Our Ref: FG/47/18/HH
Your Ref:

Town & Country Planning Act 1990 (as amended)
Town & country Planning (Development Management Procedure) (England) Order 2015
Application for Planning Permission for Works or Extension to a Dwelling

Development Single storey rear extension & ramp to front elevation
Location 7 St Malo Close Ferring

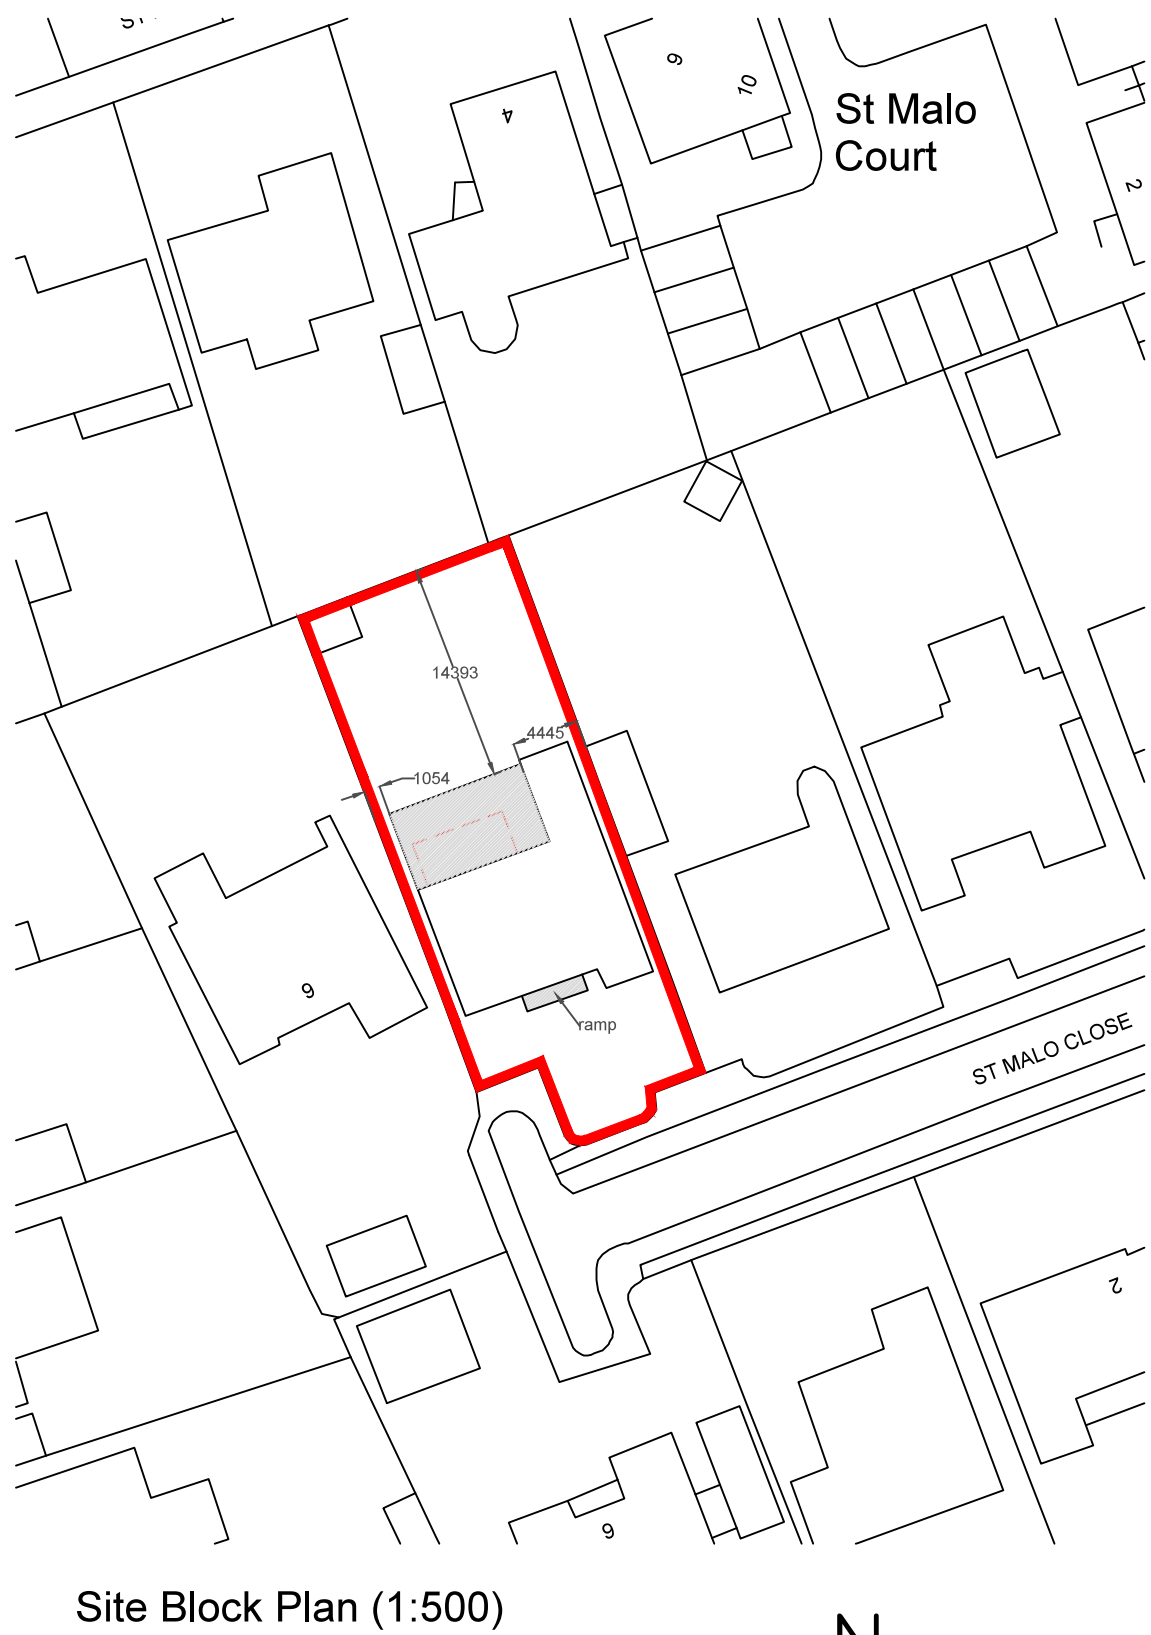
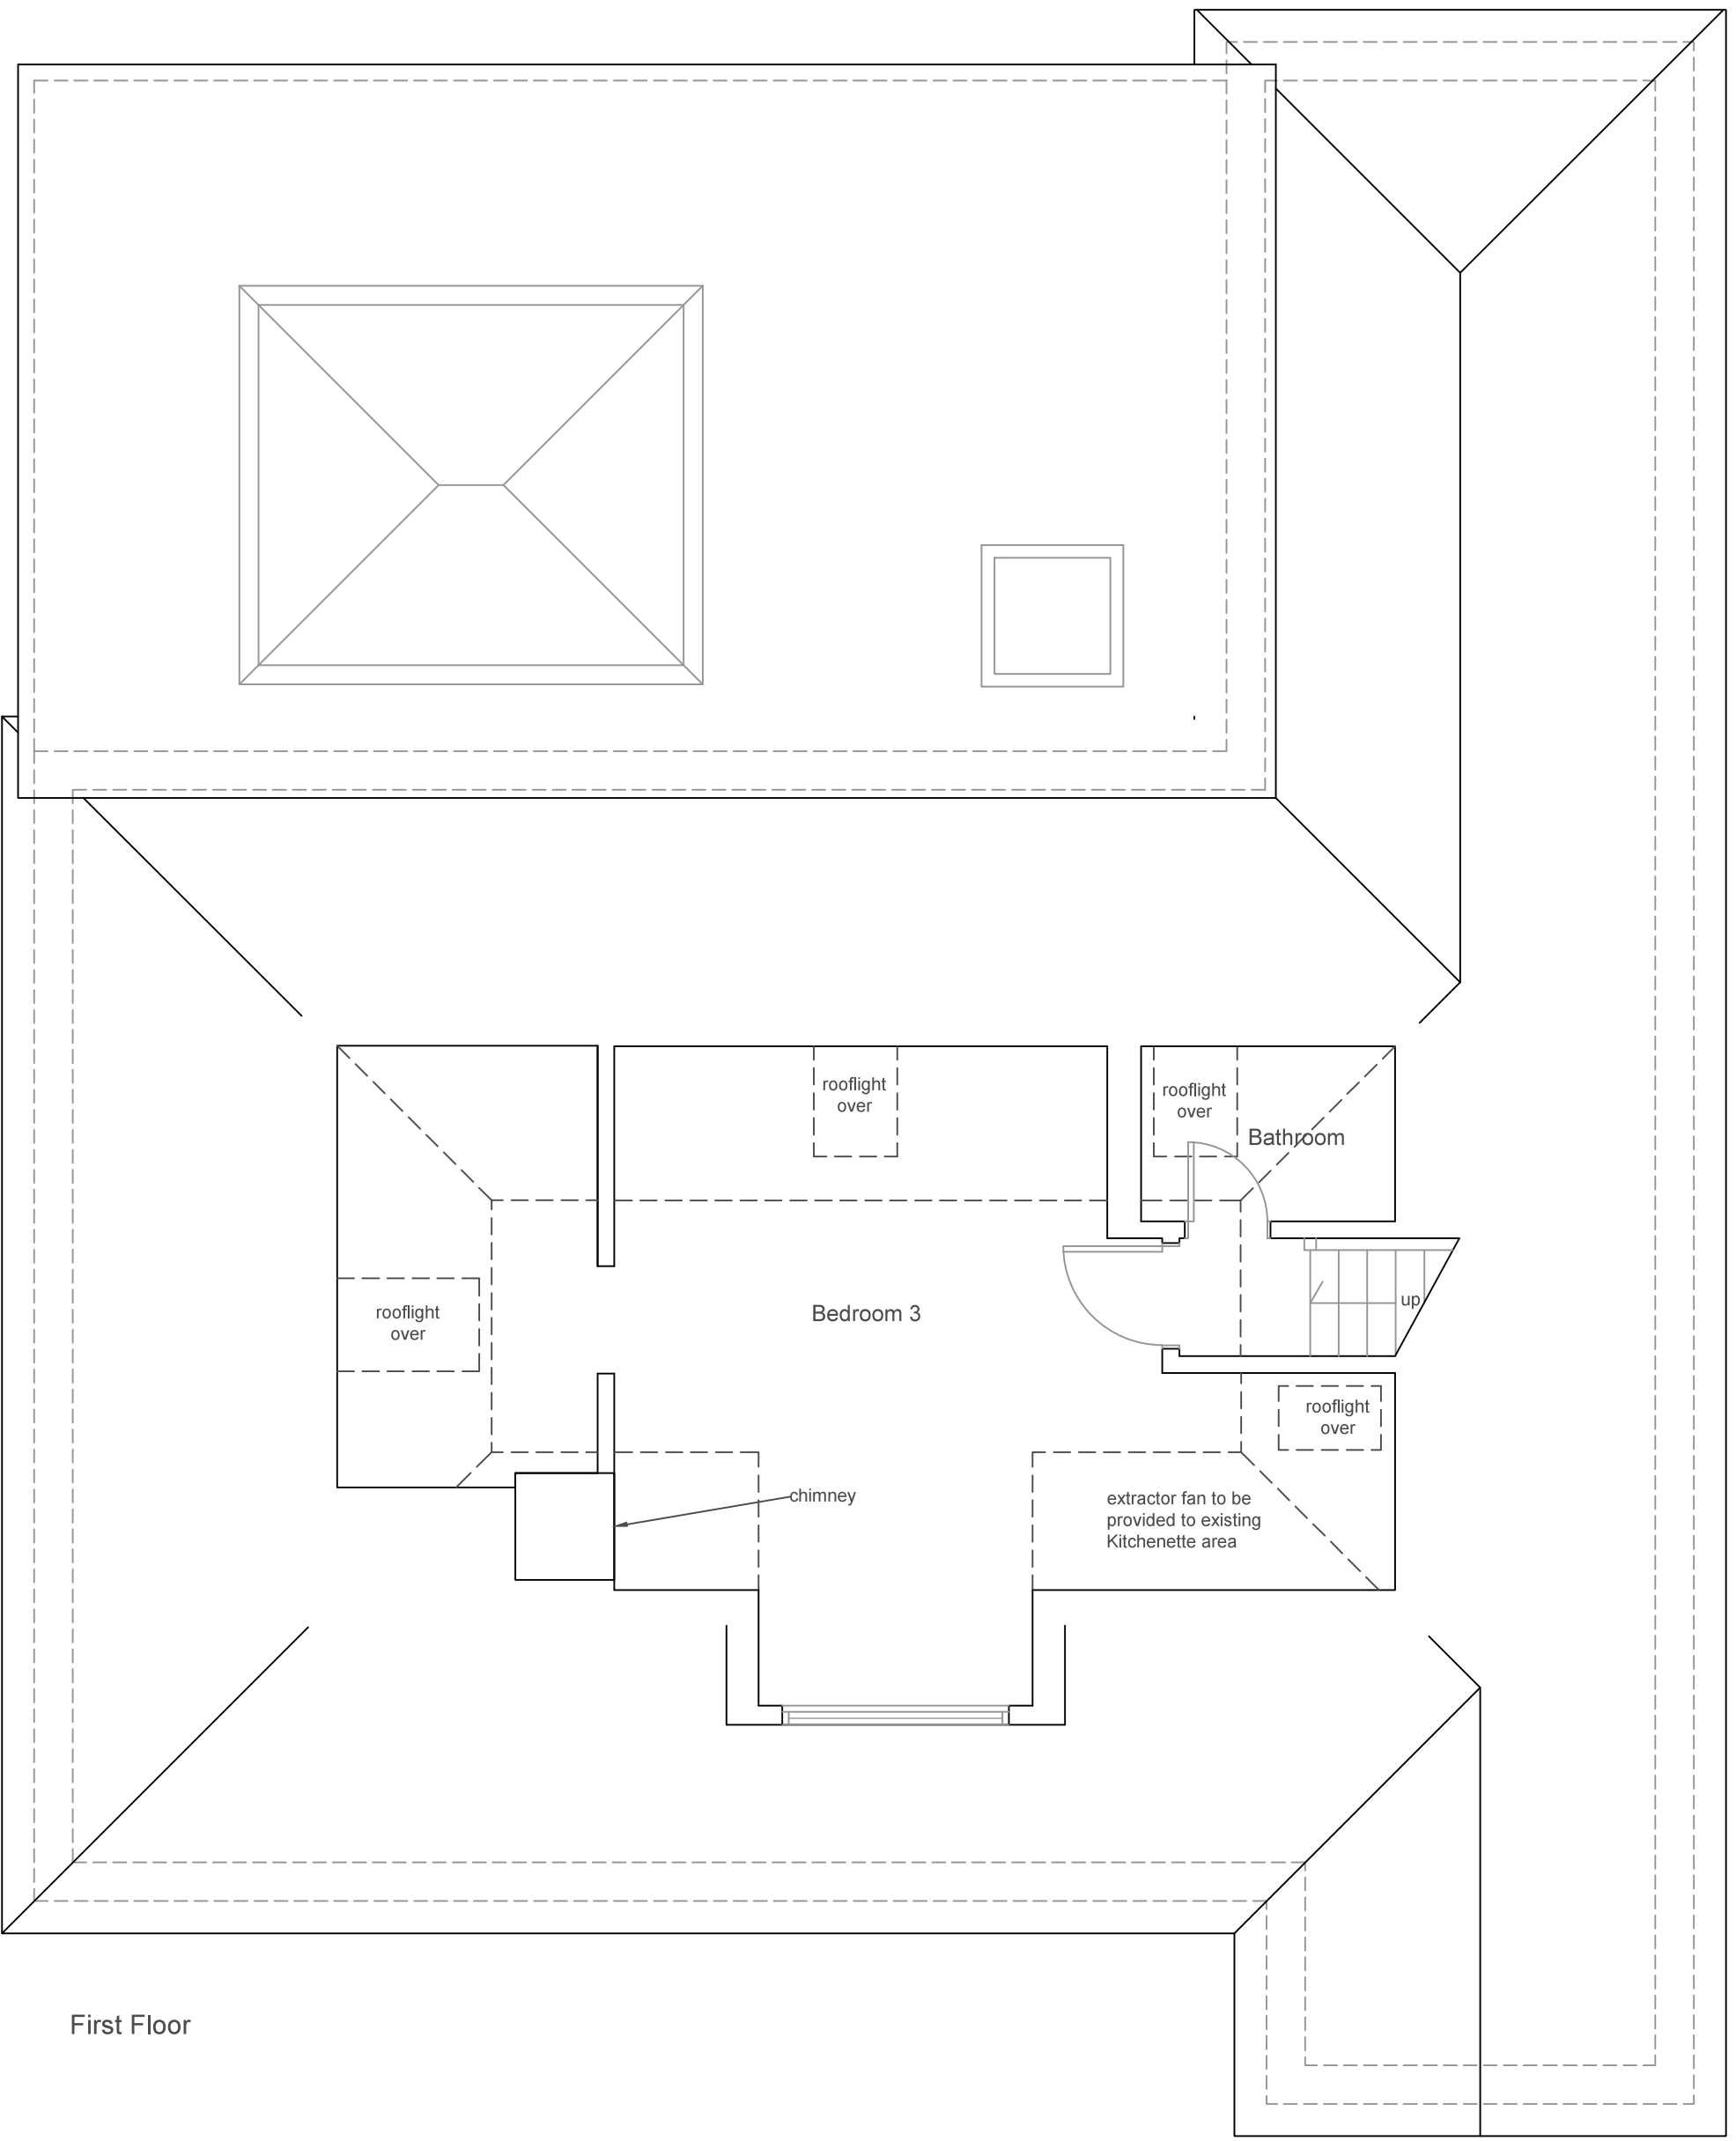
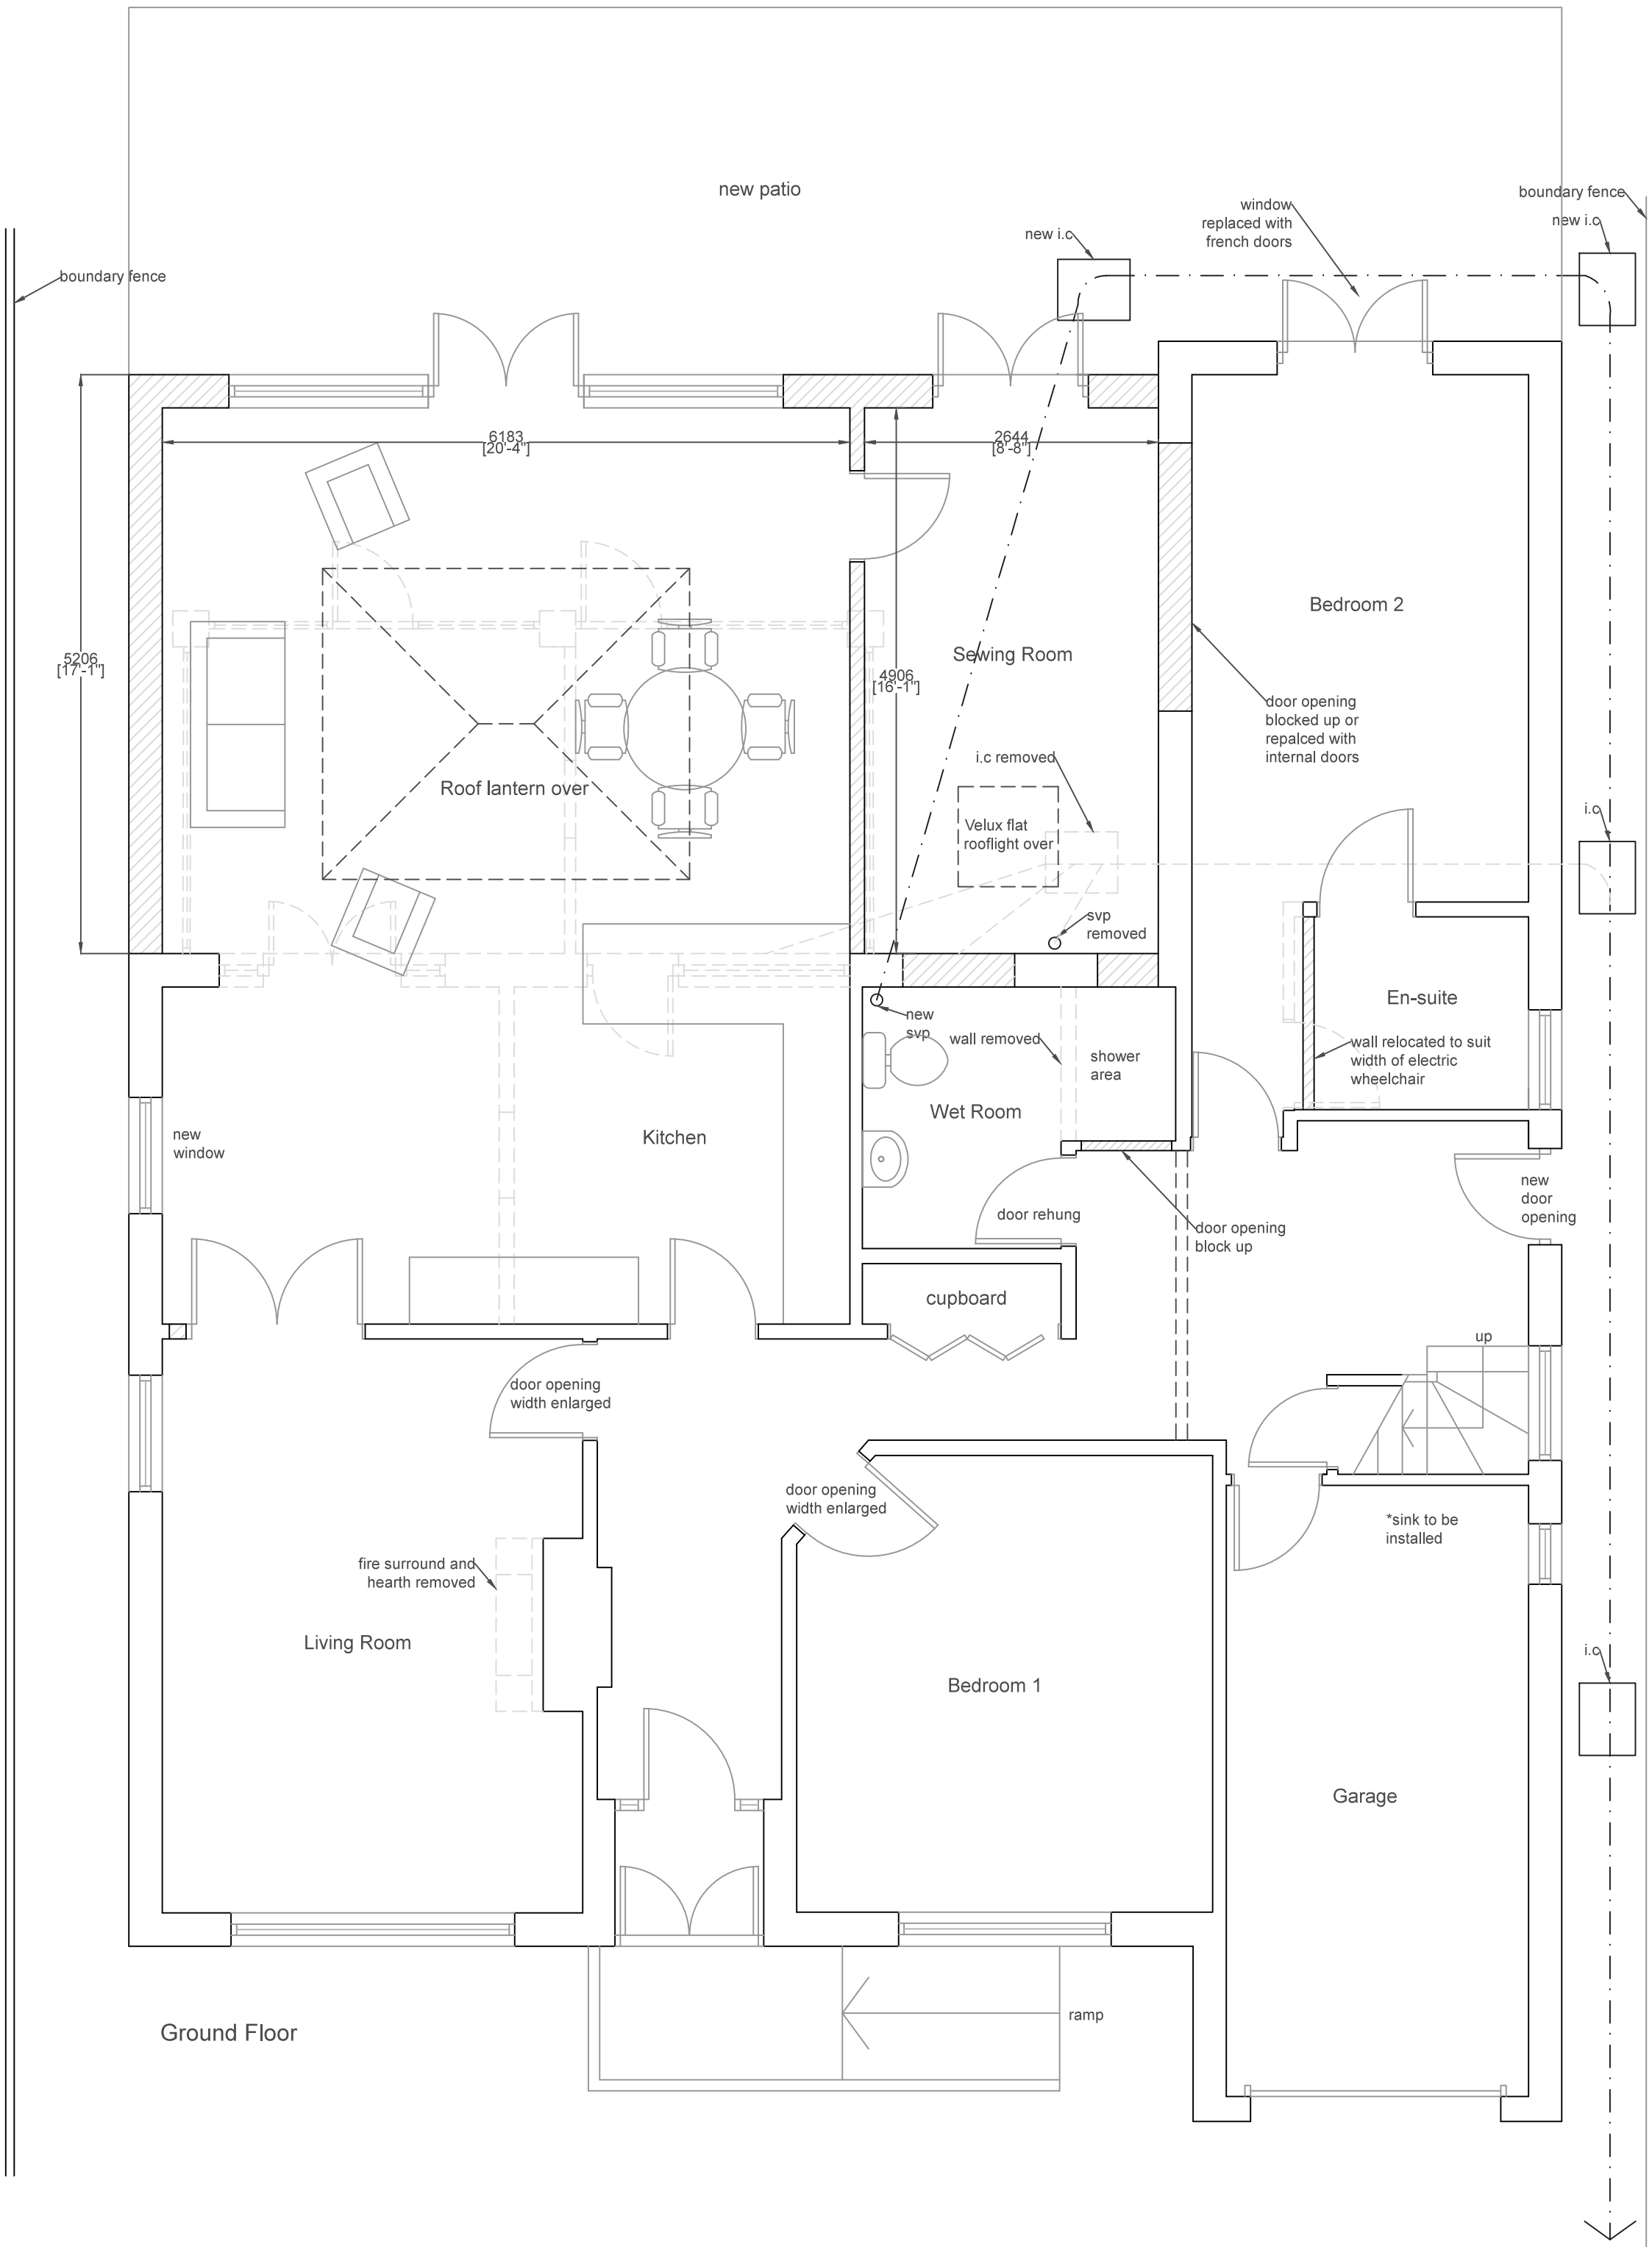
I have spoken with Planning Officer, Andrew Wood, regarding the ramp that is shown on the plans. We believe it should form part of the application and so I have added it to the description. Please could you forward revised block plans to show the position of the ramp and confirm your acceptance of the amended description.
